DOC20/390460

22 May 2020

**Modification Application for Spring Farm Advanced Resource Recovery Technology Facility (MP 05\_0098 MOD 6) - Liquid Waste-water Treatment Plant**

## **Attachment 1**

Figure 7-1: Cumulative predicted 99th percentile ground level odour concentration

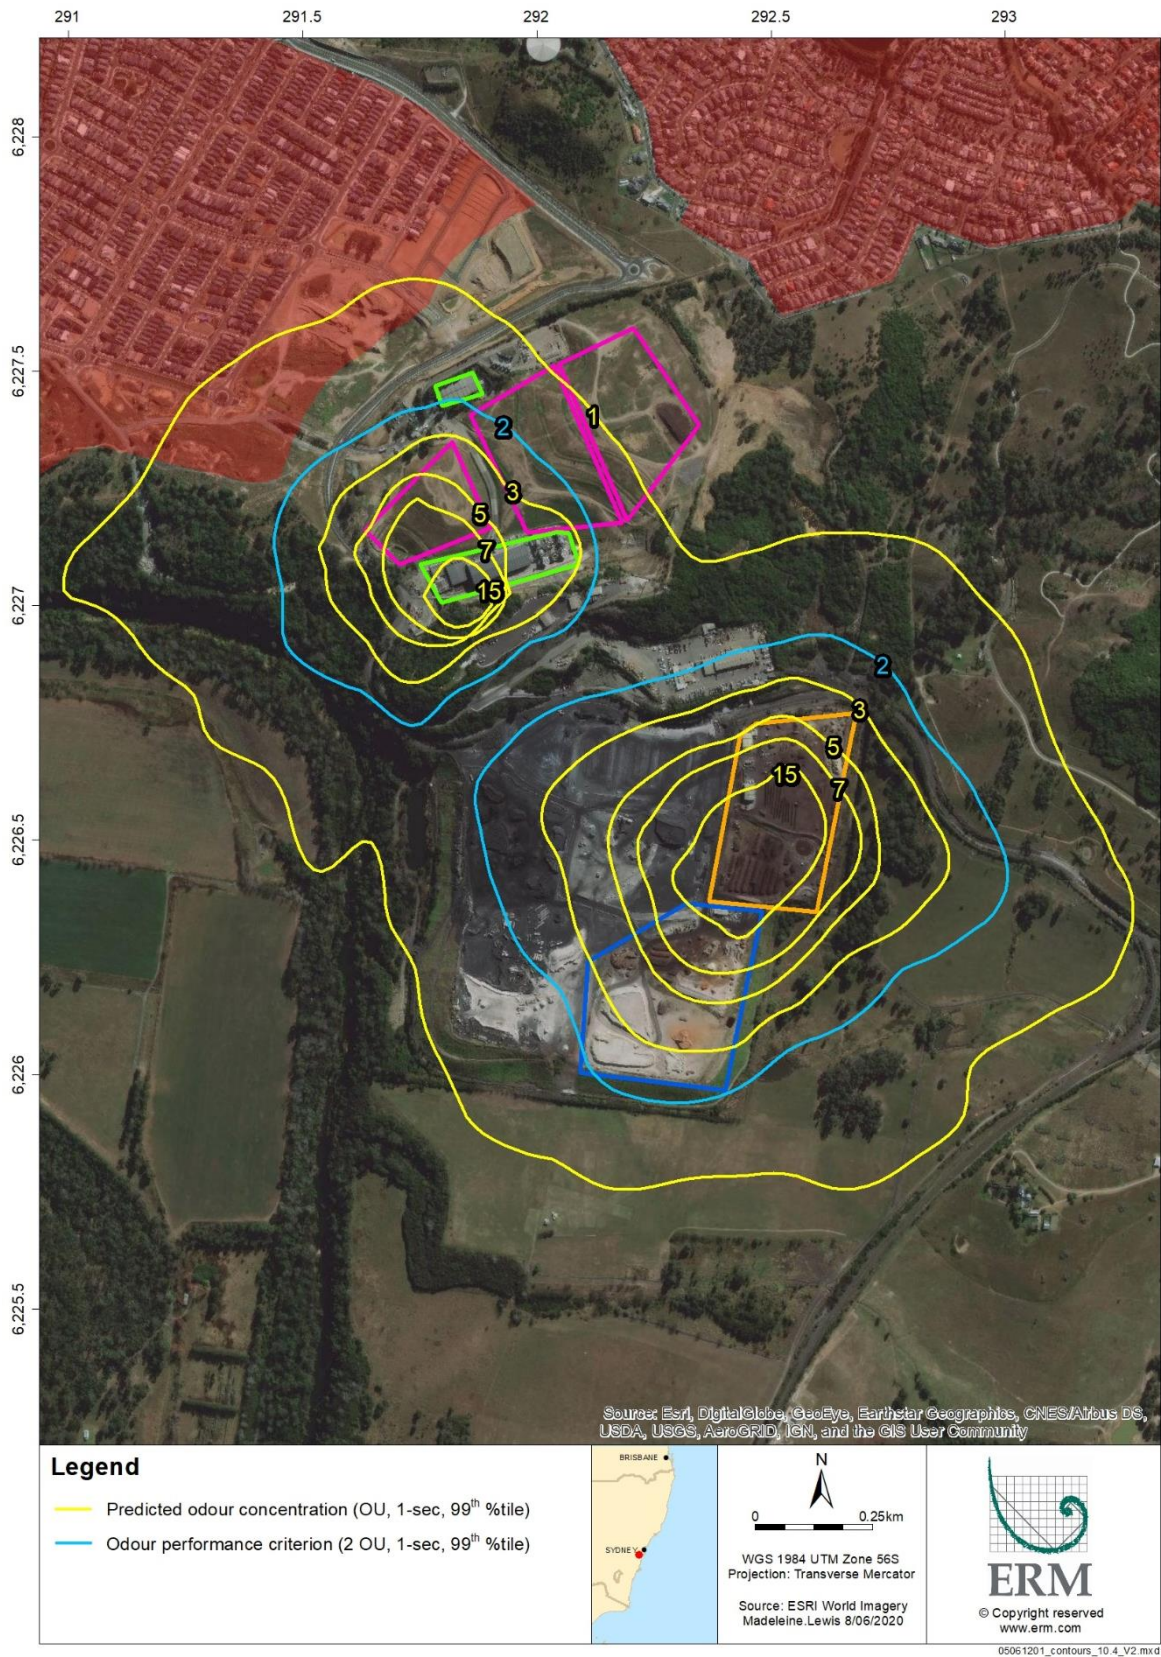
- ERM's April 2019 (MOD 6) Odour Assessment (Figure 7.1) provided odour modelling contours that show no odour impact from the combined SUEZ waste facilities to the nearby suburb of Mount Annan and that the facilities only partly impact the Spring Farm residences. This modelling does not reflect the recent offensive odour impact experienced in these suburbs that the EPA has confirmed is caused by the SUEZ Spring Farm waste facilities. The EPA is addressing this matter in separate regulatory action.
